**WEST SUSSEX COUNTY COUNCIL
HIGHWAYS AND TRANSPORT SERVICES CONSULTATION**

SUBJECT: BR/110/08/ - Outline application for the redevelopment of premises to provide 14 no. apartments

18, Lennox Street, Bognor Regis, West Sussex

Ground Floor 2 No Apartments

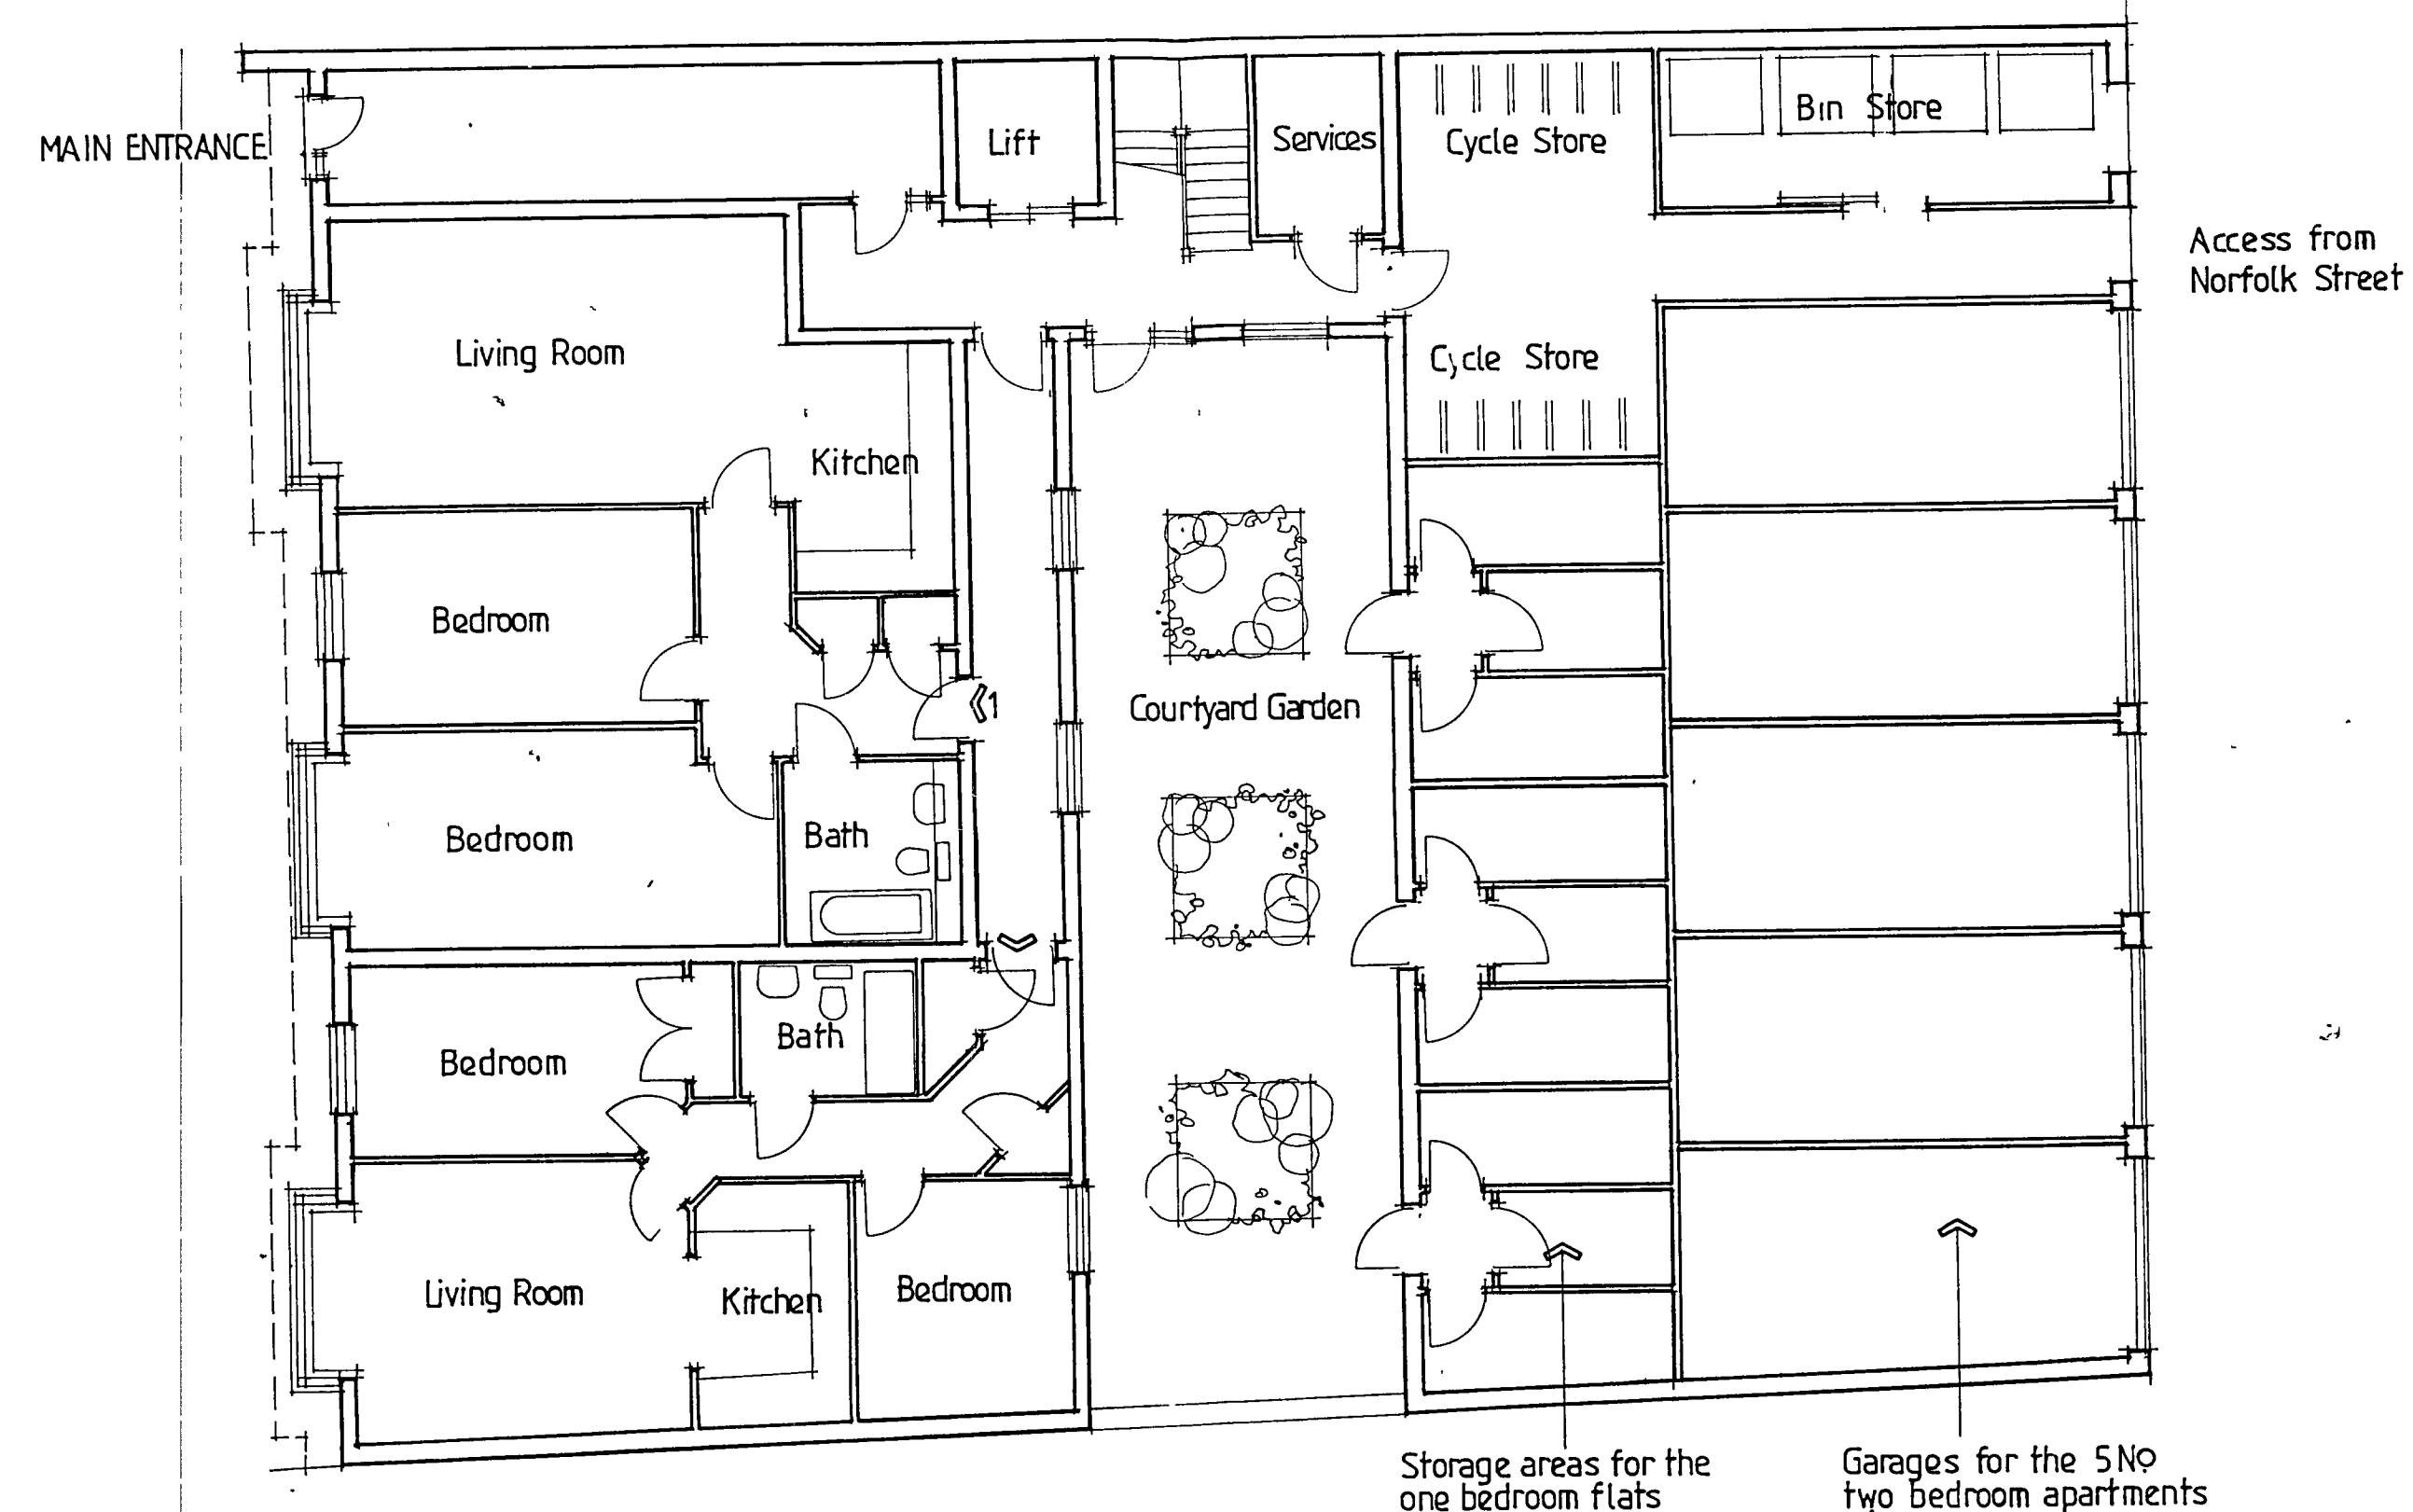
Five car parking spaces are now to be provided for the benefit of the two bedroom units. These are to have direct vehicular access from Norfolk Road. No significant concerns would be raised with the provision of access. The proposed level of car parking has been decreased from the initial consultation and no concerns would be raised through the provision of five car parking spaces as this is still within the WSCC maximum parking standard. The site is located within Bognor Town centre, thus enabling good access to a range of services and frequent passenger transport, which should encourage an increase in walking, cycling and the use of passenger transport, as well as minimising the number and impact of motorised journeys. It is noted that improved access is also now provided to the cycle store, which isn't now hindered by the proposed car parking.

No objection would be raised to the proposals.
